**ADC Planning Consultation
Response from the Historic Buildings Adviser**

Application Number	AB/36/15/L
Address	71 Maltravers Street, Arundel BN18 9BQ
Description	Application for listed building consent for a ground floor rear extension & internal alterations including relocation of kitchen, reconfiguration of stairs, insertion of ground floor W/C & modernisation of first floor partitioning.
Case Officer	Ross Leal
Site Visit	Previous

No Objection subject to amendment

Drawing No **14696/ 02** Status Revision

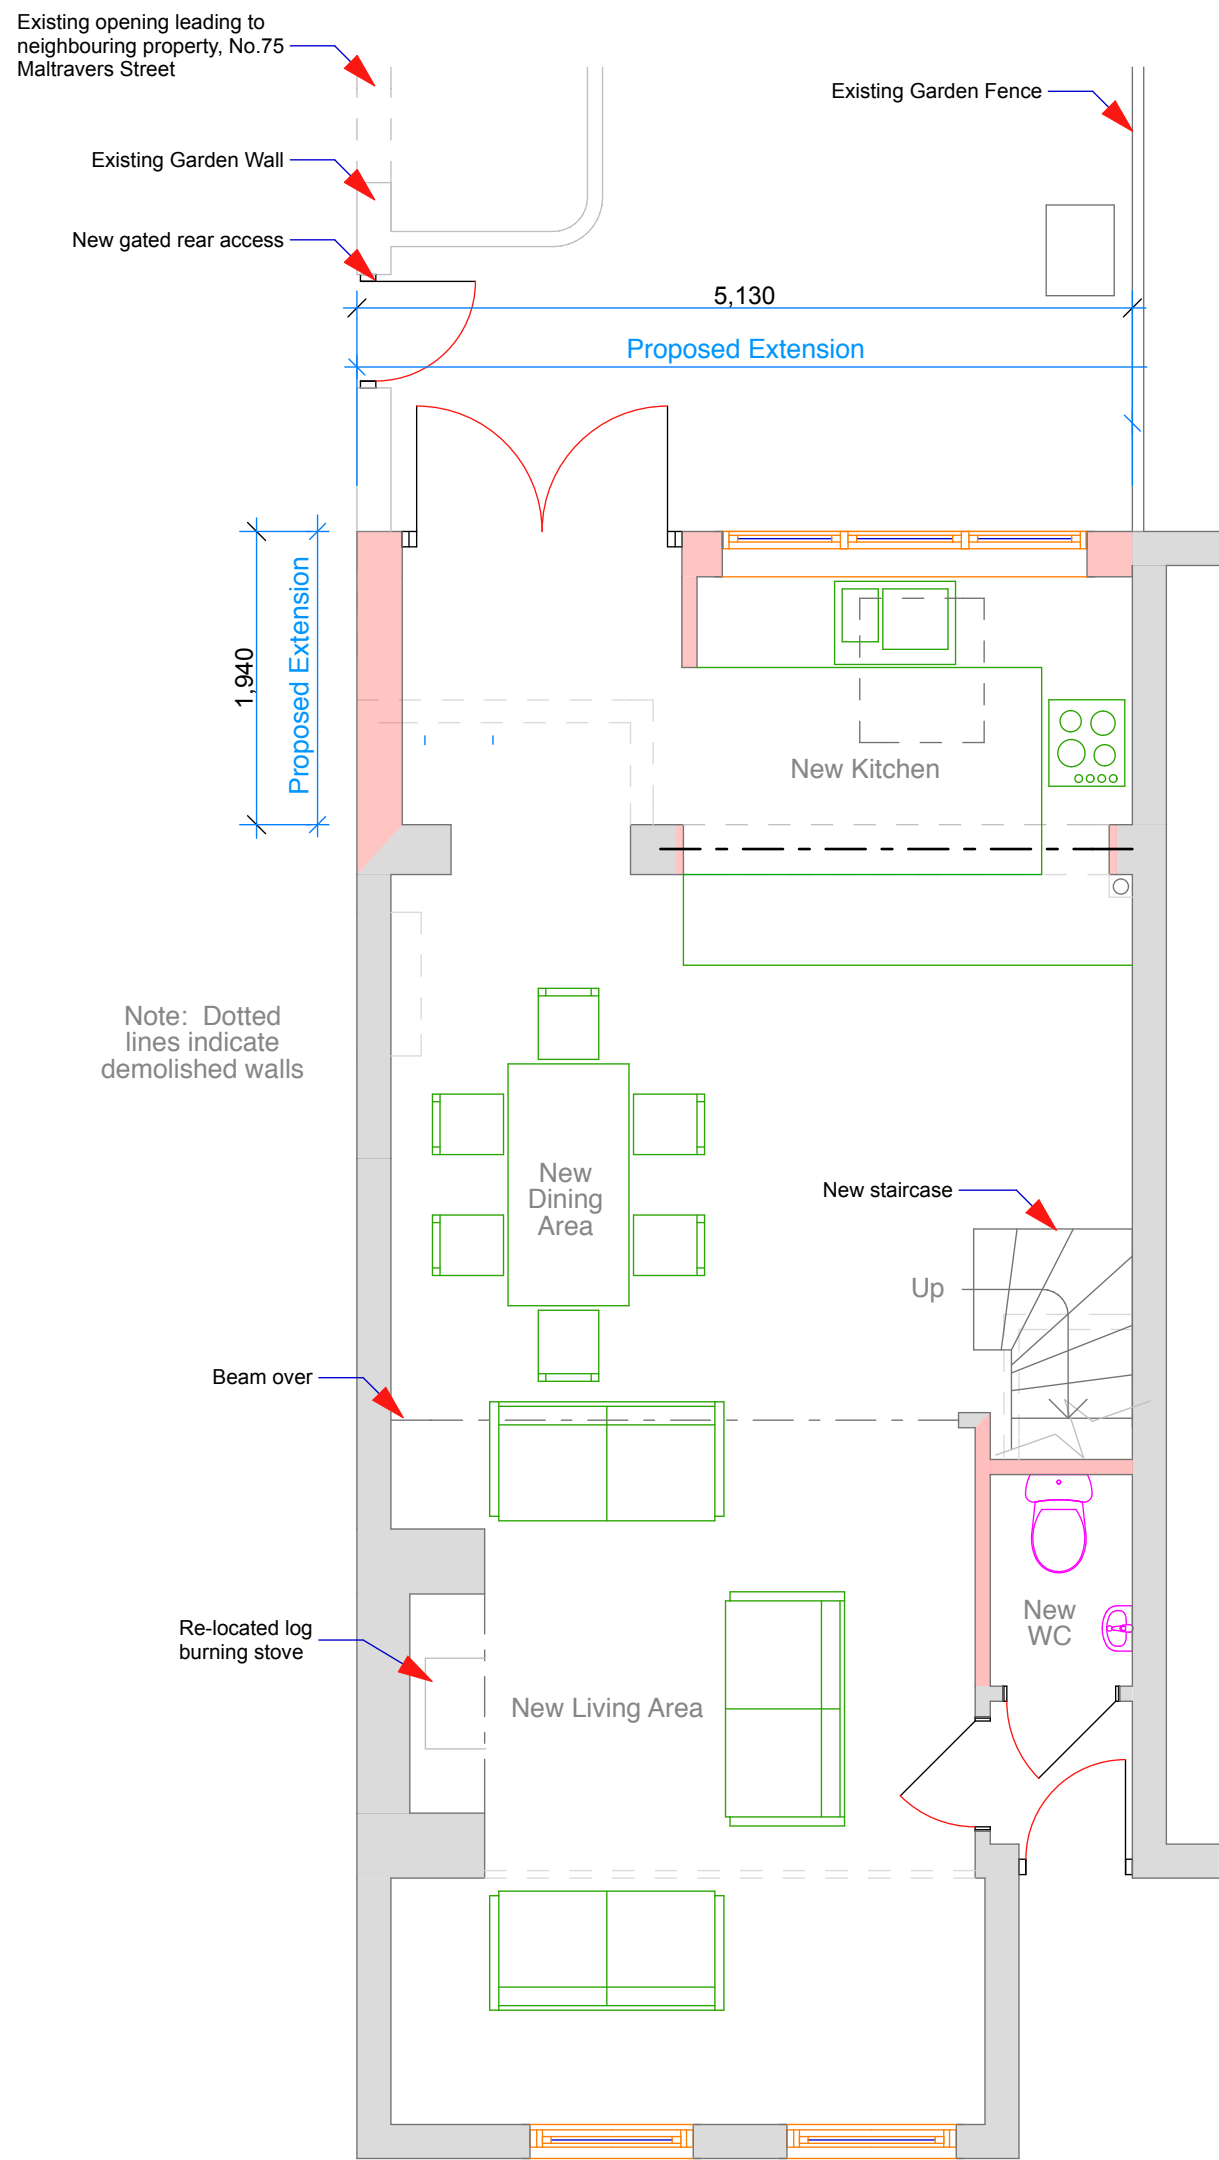
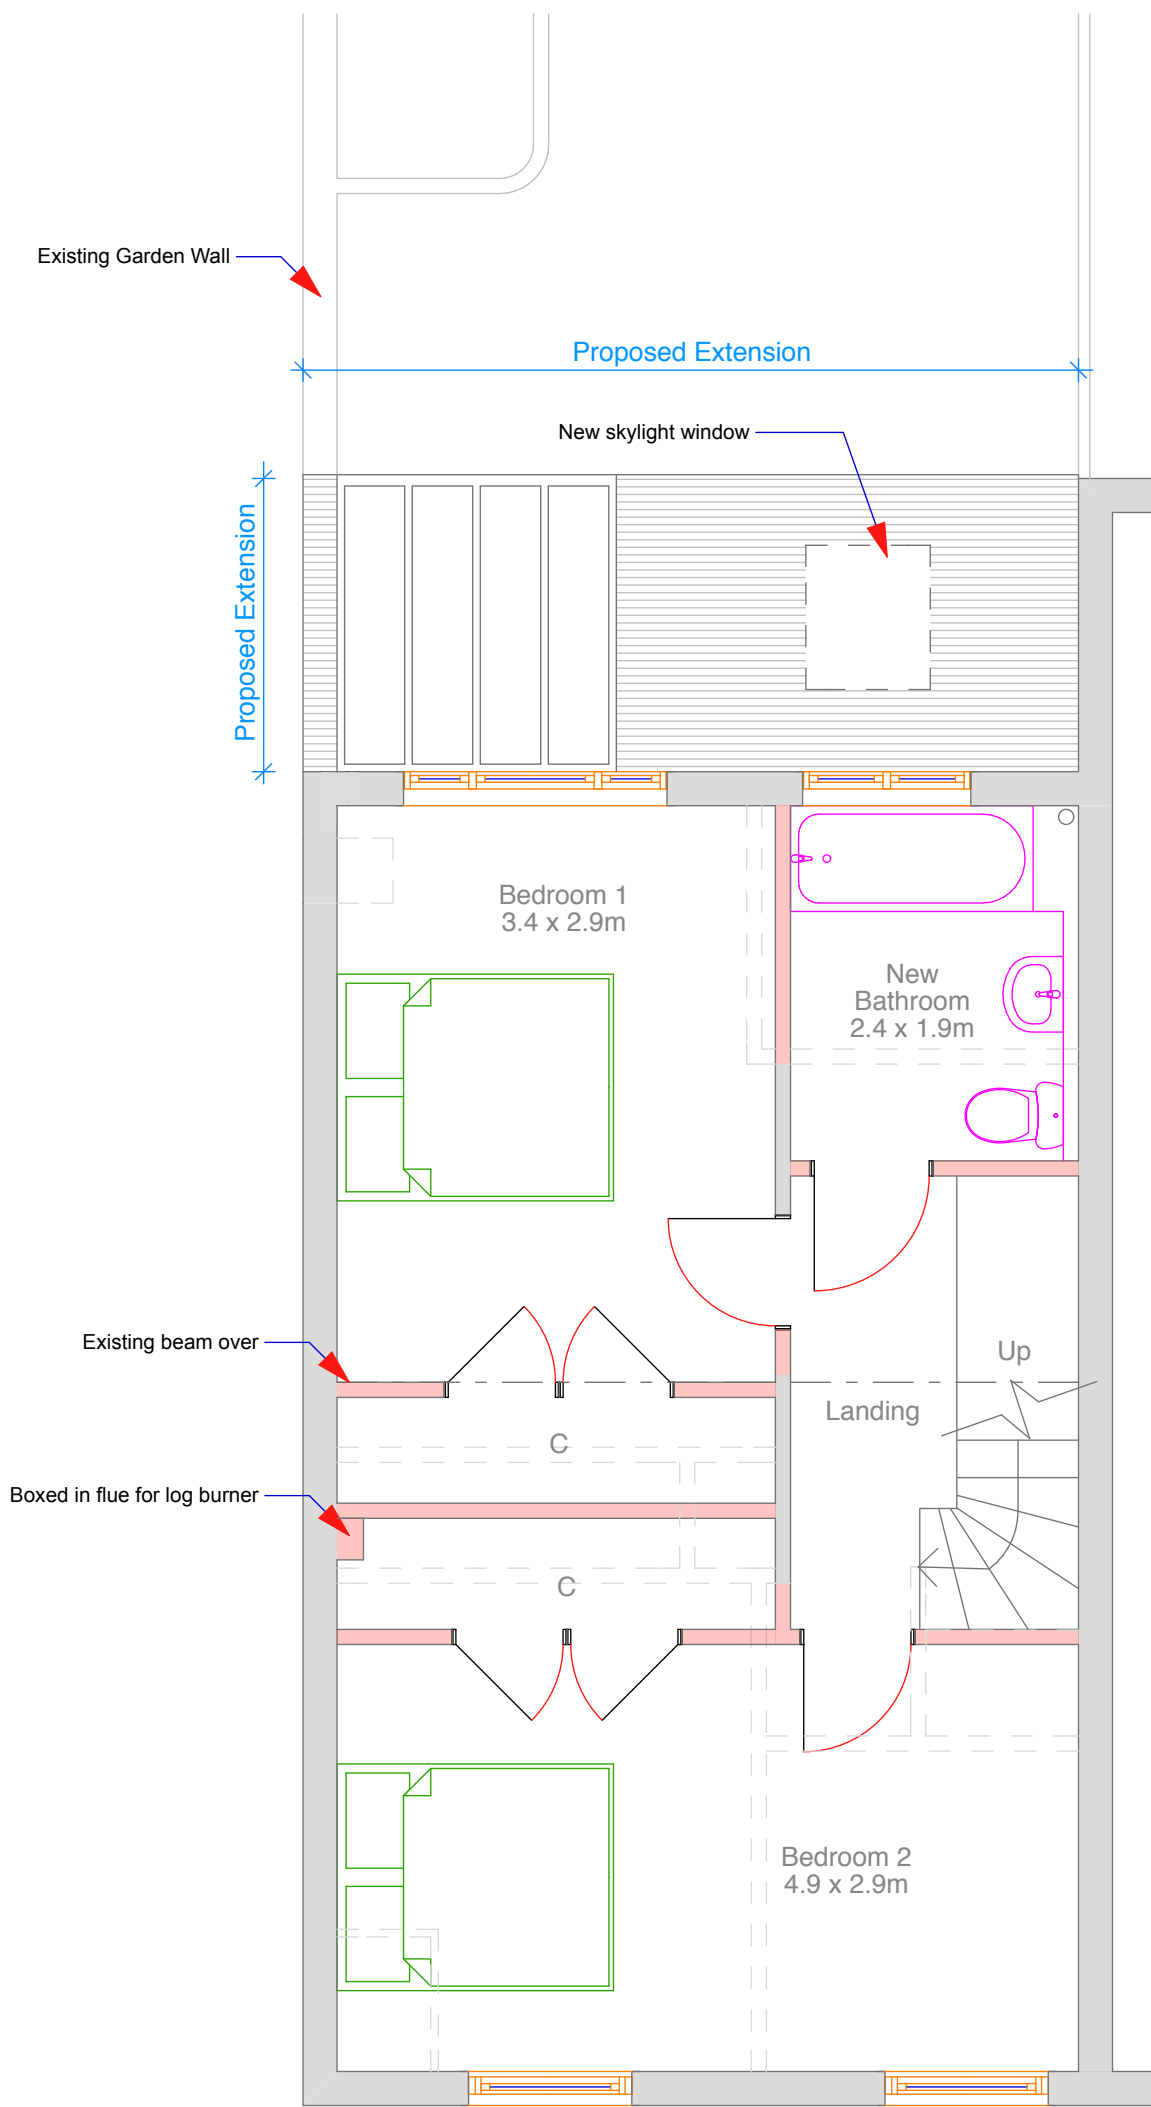
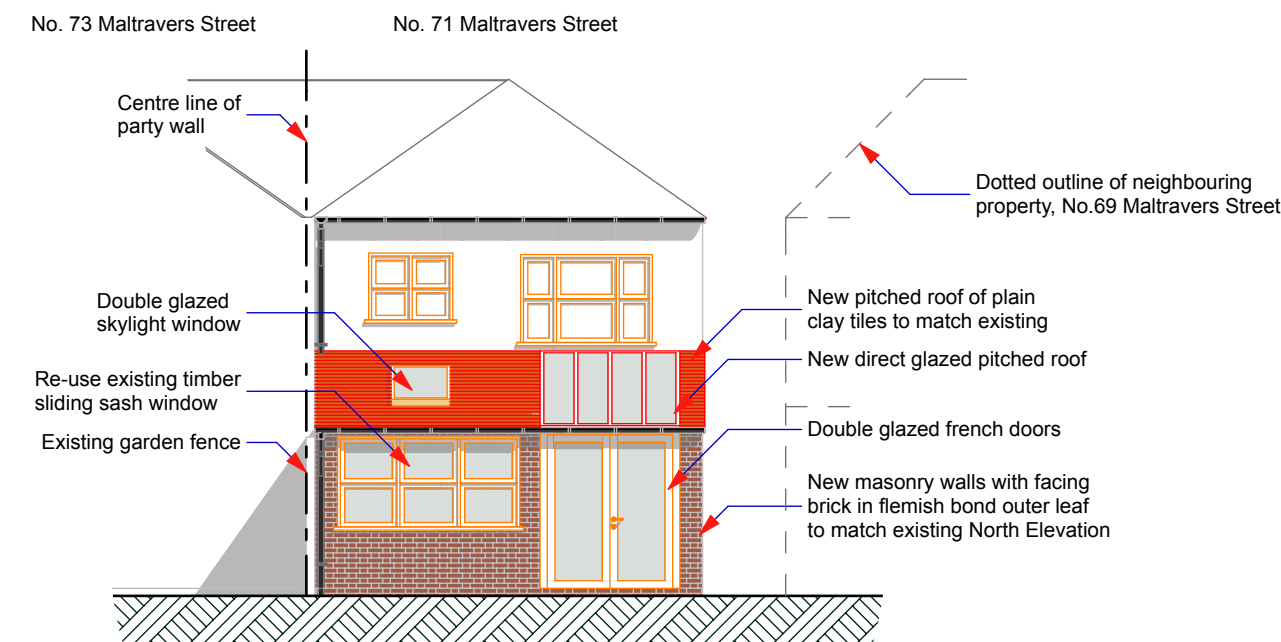
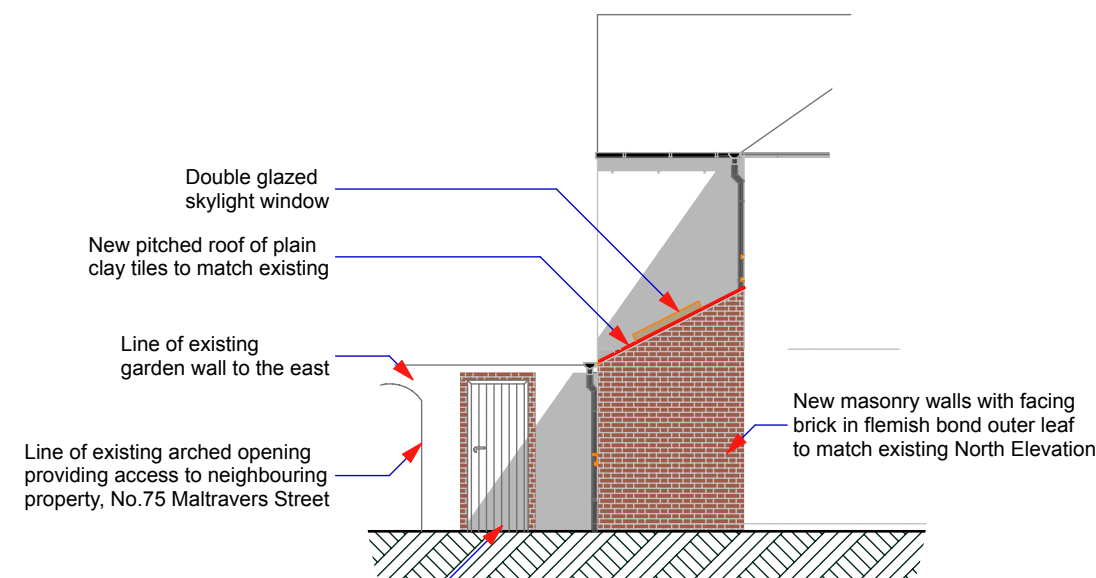
Whilst this scheme is generally acceptable and follows pre-application advice, there are some amendments required before this proposal can receive full support. These relate only to the ground floor and are as follows:

- The width of the opening created by the removal of the rear window should be retained and the wall simply cut down. The removal of further wall results in excess loss of historic fabric and erodes the legibility of this change. There should also be a down stand of wall retained which needs to be shown in a section.
- The glazed area of roof appears excessive for such a small roof and will result in unnecessary complexity to the slope. This should be removed from the scheme.
- The French doors at the rear would benefit from some form of division so that they better relate to the fenestration
